Response to Submissions Report

State Significant Development Application SSD 9113
Randwick Hospitals Campus Redevelopment - Stage 1

6 November 2018

Health
Infrastructure

1 ASB BASEMENT 2 | CAR HEADLIGHT SPILL EXTENT 10m
1:50 @ A1 or 1:100 @ A3

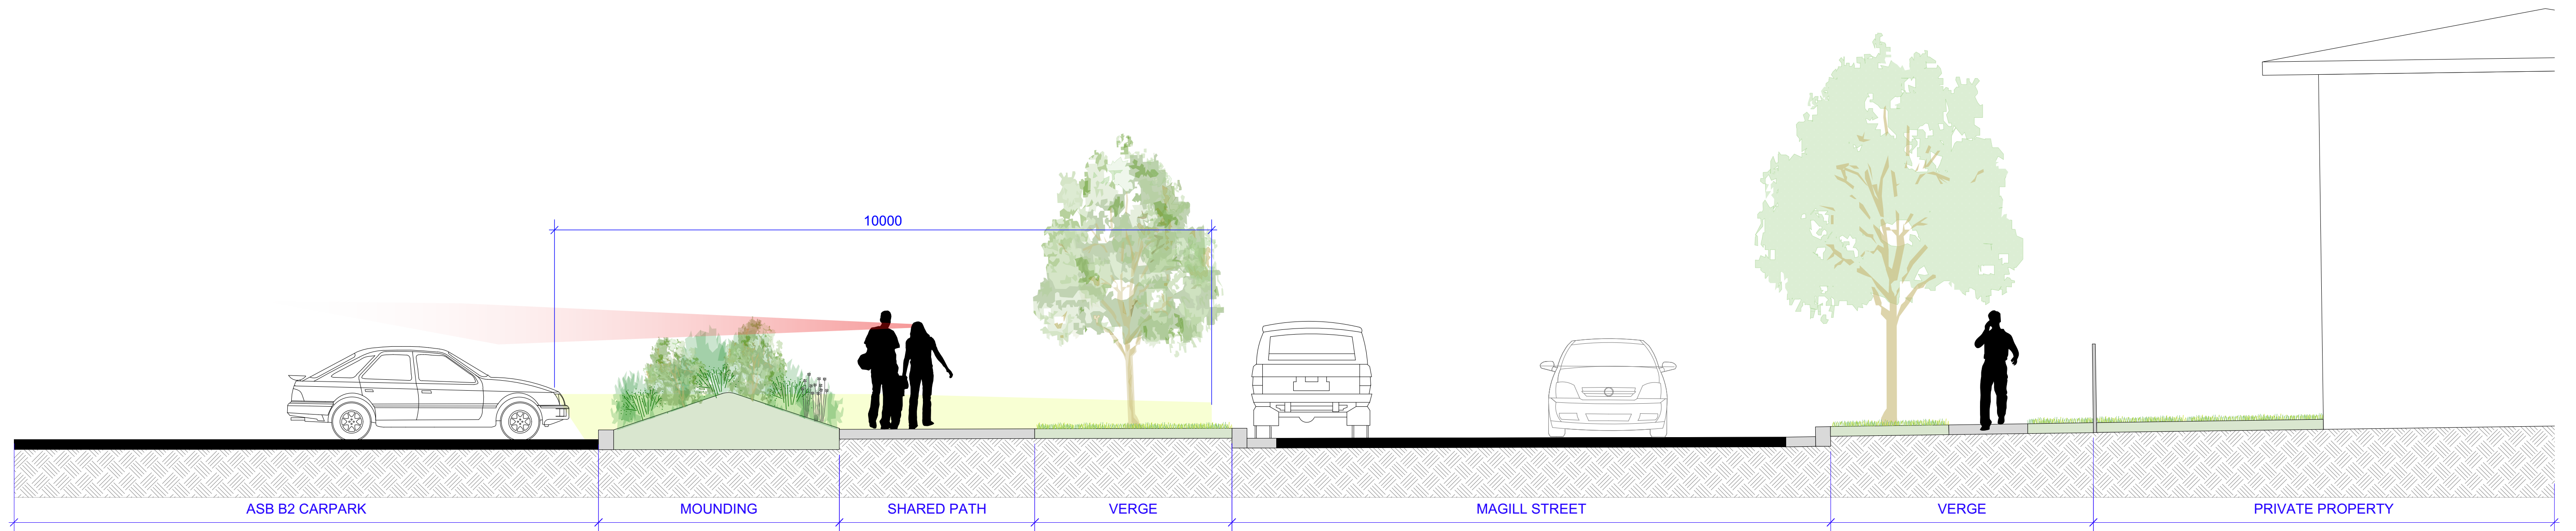
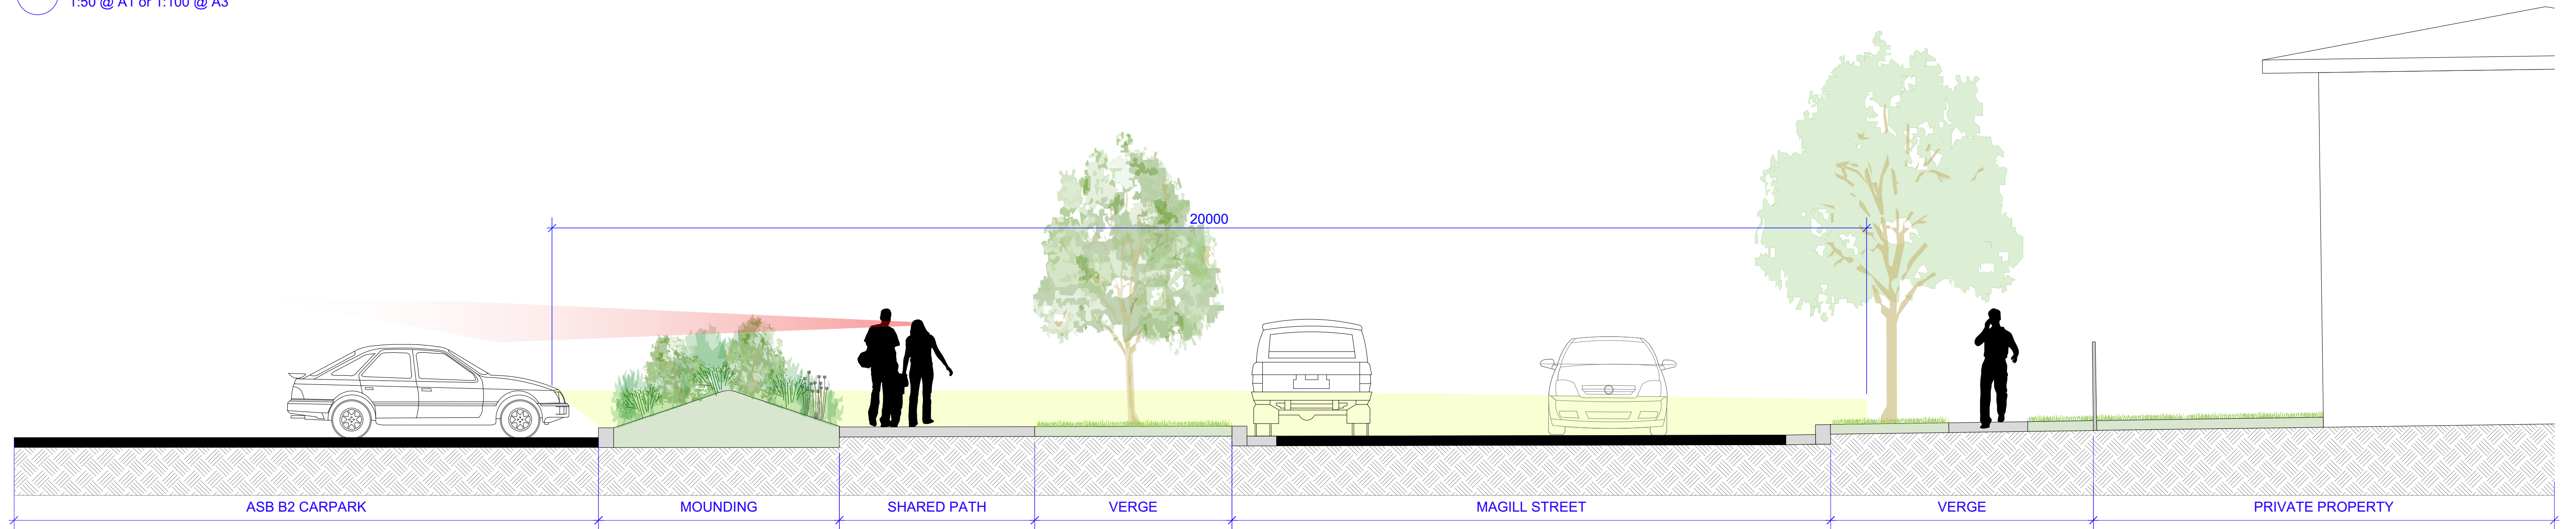
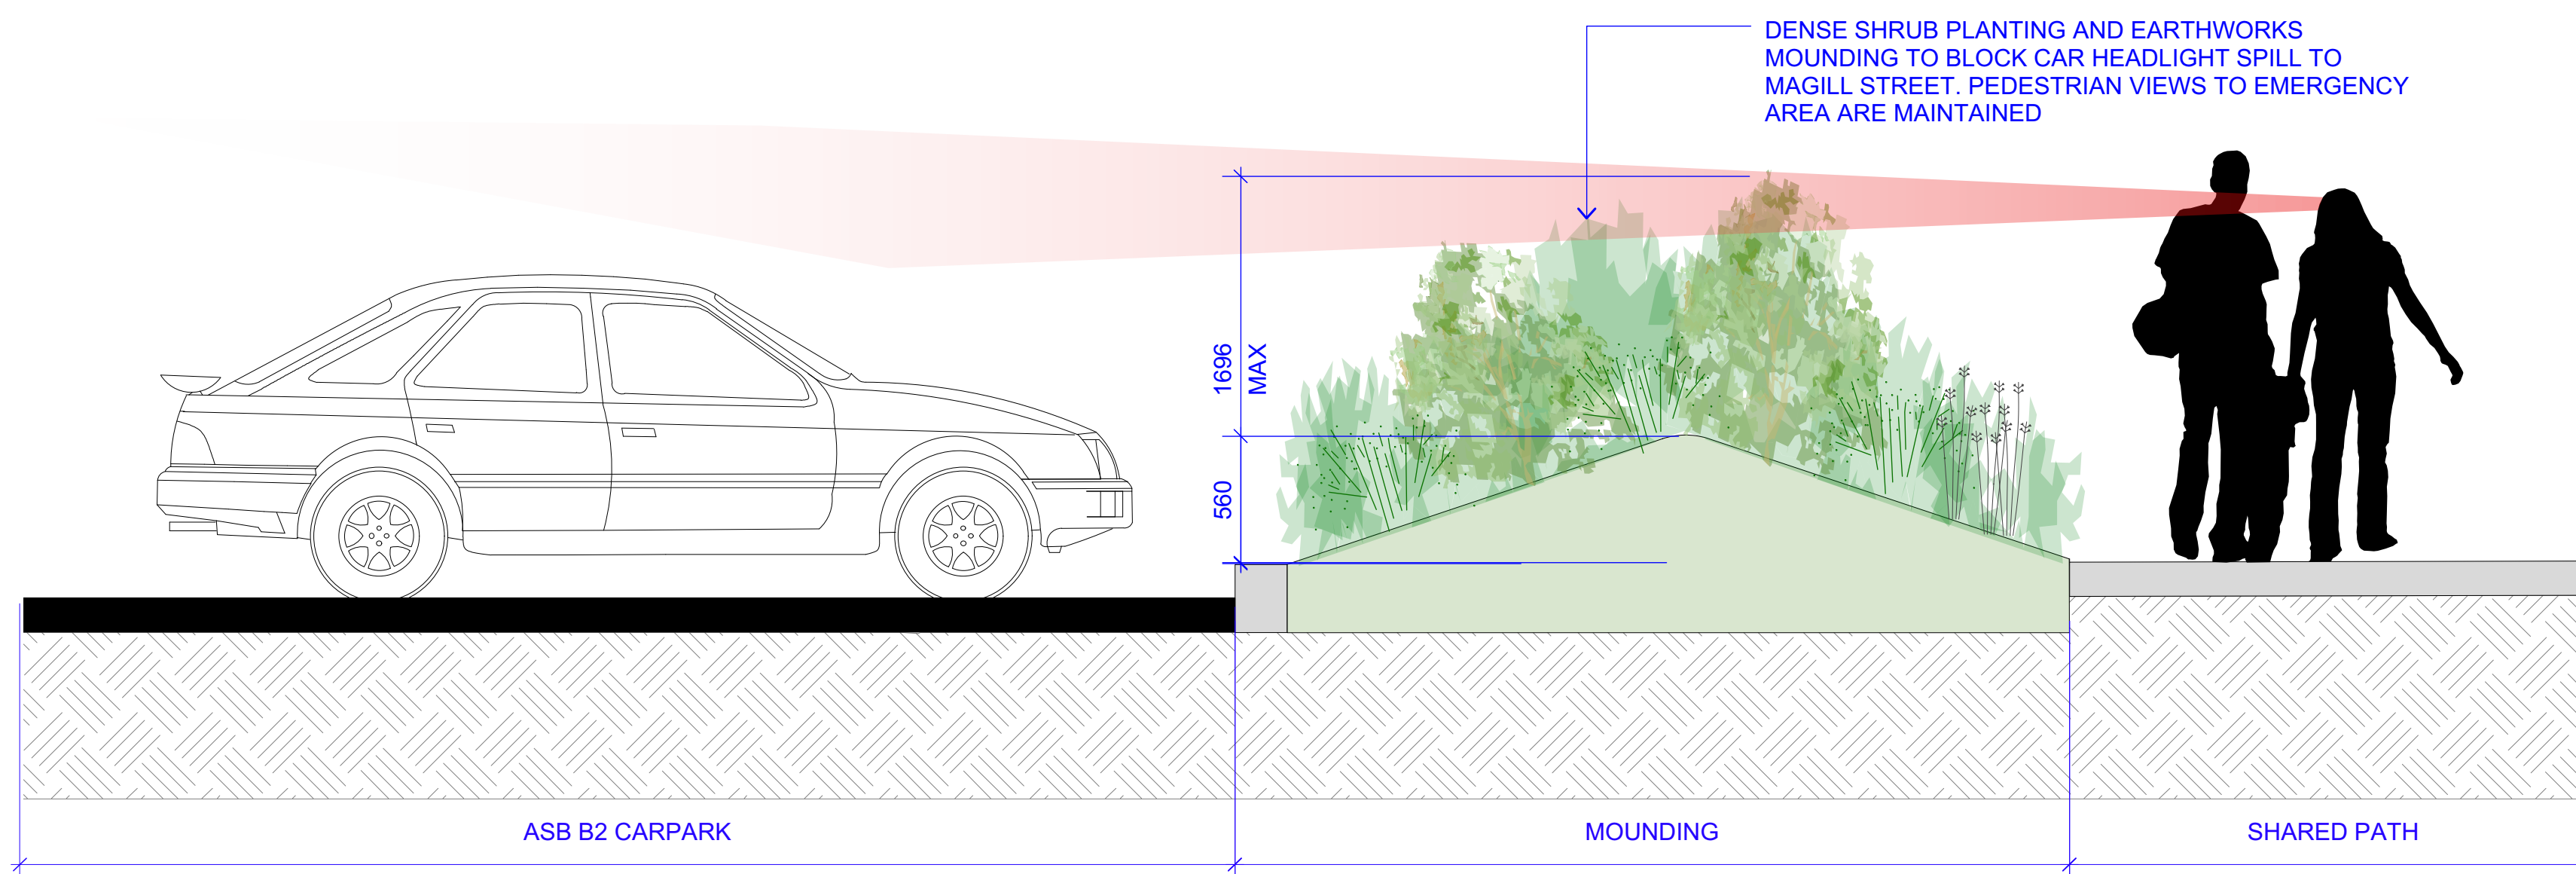
Issue	Response
1. The key issue relates to the traffic and associated amenity impacts from locating emergency access on Magill Street. Please reconsider the location of the vehicle access off Magill Street or demonstrate that the amenity impacts can be adequately mitigated.	Vehicle Access Location In developing the composition of the ED in the ASB, several vehicle access locations were considered during the Concept Design Stage. This was refined to three possible, practical access location options: Botany Street, Hospital Road and Magill Street. <u>Botany Street:</u> Vehicle access off Botany Street was discounted as it congested the single point of entry for all vehicles along Botany Street and provided a less intuitive point of arrival with no visibility of the ED entrance. Further, vehicle access required an extensive ramp down to the ambulance bay at Level -02. This significantly compromised the landscaping area along the Botany Street interface. <u>Hospital Road:</u> Vehicle access off Hospital Road was discounted due to the critical need to separate the emergency access away from the loading dock. If not separated, loading vehicles may cause unacceptable access restrictions in emergency situations. Space allocation for an ambulance bay on Hospital Road would distance and compromise the close collaboration between the ASB Core and Randwick Hospitals' Campus. Further, the steepness of Hospital Road presents difficulties negotiating levels of the vehicle access. <u>Magill Street:</u> Vehicle access off Magill Street was chosen as the preferred access point because it included the following advantages: (a) maximises the number of possible routes for ambulances to arrive and leave from the ASB via Botany Street or Hospital Road. (b) provided ambulances, patients and visitors intuitive wayfinding with clear visibility of the ED lobby from the access; (c) The lobby facilitates "minimum hassle" connectivity to "support facilities" on Levels -01 and 00 such as the Front of House, Patient/Staff Lifts, Amenities, and Café; (d) Configuration of the ASB building supports flow between support facilities and "medical facilities" on higher levels such as the Operating Theatres, IPUs, ICUs and so forth; and (e) provides a direct path to the carpark. Amenity The key matters likely to be impacting amenity for residents on Magill Street are considered to be: (i) Traffic, and the accompanying (ii) Noise and (iii) Light issues, potentially causing "Sleep Disturbance" between the hours 10:00pm and 6:00am. Traffic movements in Magill Street contained in the Arup Transport Assessment (Appendix I to the EIS) were reviewed. The

Issue	Response
	results proposed that opening Magill Street during night hours (10:00pm – 6:00am) would see an average of 2 vehicles every 5 minutes (25 vehicles per hour (vph)). Based on the assessed traffic movements, noise and sleep disturbance assessments concluded that the utilisation of the vehicle access and ED will satisfy all relevant noise criteria during day, evening and night periods. Thus, the Magill Street vehicle access was found to be a reasonable and feasible environmental assessment outcome. Intermittent noise events generated by “through traffic” (on an open Magill Street) option, which do not utilise the ED, were found to potentially exceed sleep awakening levels. However, given the low traffic volume through night periods, the infrequency of acute noise events would be unlikely to affect the amenity of residents. In this regard, it is noted that the Hospital Road carpark accesses are closed during the “evening and night” periods from 6:00pm to 6:00am. Notwithstanding the assessed “satisfy all relevant noise criteria” (which included the “evening and night” periods and noting the hours of access to the carpark from Hospital Road), special consideration has been given to identifying reasonable and feasible measures to mitigate noise and light issues, if any, which may cause sleep disturbance. The following measures are being considered: • Opening Magill Street (24 hours) for a trial period of 6 months to test and report on the level and nature of amenity impacts on residents and the planning merits of the street remaining open; • Noise-reducing surfaces on Magill Street to reduce “squeal” from tyres; • Road and site signage to alert users of the need to minimise traffic/people noise impacts to neighbouring areas; • Appropriate sound-proofing barriers and surfaces in the drop-off/Short stay area to reduce people noise which includes closing doors; • At receiver treatments such as acoustic glazing and treatments to ventilation openings/air vents; and • Buffer planting along landscaped areas to obscure headlights, where possible.

INTRODUCE A ZONE FOR NEW LANDSCAPE
MOUND AND LOW HEIGHT PLANTING TO LIMIT
LIGHT SPILL ONTO MAGILL STREET

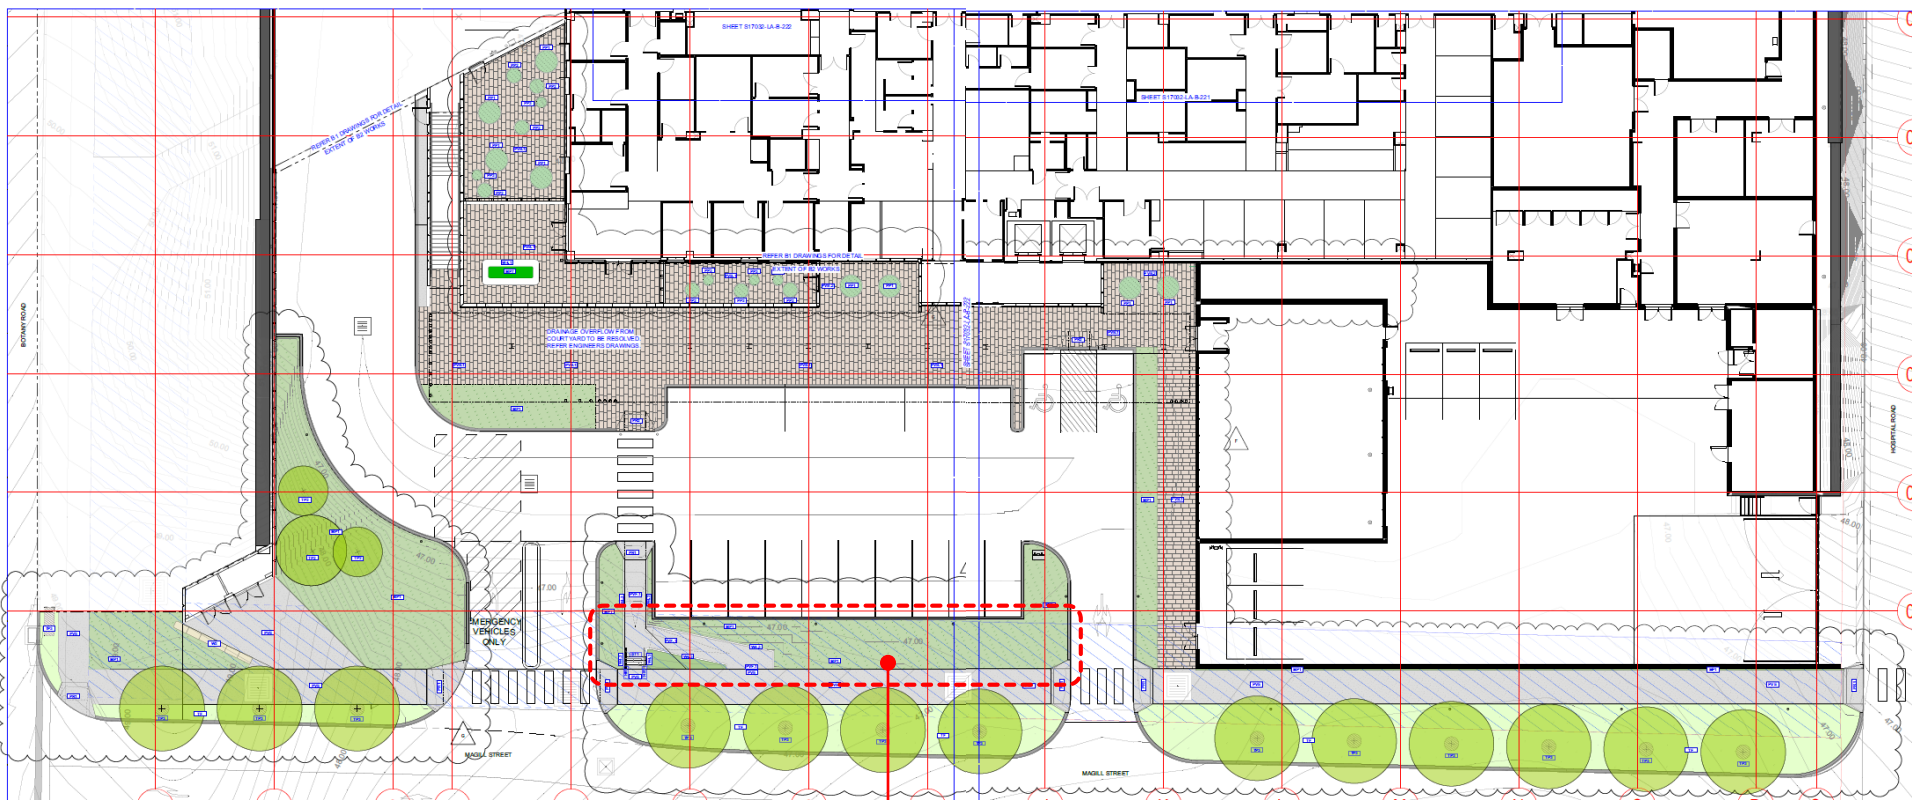
Noise and Vibration – Operation Council recommends that alternative locations be considered for the loading bay and car park access to protect the amenity of residents on Magill street. Council considers that the loading dock should be located further away from the Magill Street end. Council stresses that noise from loading and unloading associated with the proposed loading dock during the night time period may cause sleep disturbances, in particular noise from the reversing alarms of trucks. Council understands that administration controls will be implemented to manage night time noise from the loading dock. It is recommended that these controls be included as conditions of any consent. In relation to any ongoing night-time traffic noise on Magill St, Council requests that the Noise and Vibration Impact	Car Park Access Refer to response in Issue 1 in Table 3-1 with regards to the decision not to relocate emergency department access point provided suitable mitigation measures. Loading Dock The ASB loading dock is a satellite port with movements in support of only ASB operations and limited to light and medium vehicle access. The existing campus dock array remains the primary destination for major deliveries to ASB including linen, waste and food. Consideration has been given to the loading dock location by moving it away from Magill Street to Hospital Road to limit truck movements along Magill Street and protect residential amenity. Relocating the loading dock further north would preclude the development options for the future expansion area to the north. A 4-metre-high wall to the loading dock has also been proposed to help mitigate and screen acoustic and visual impacts. HI accepts a condition in relation to administration controls to minimise night time noise.
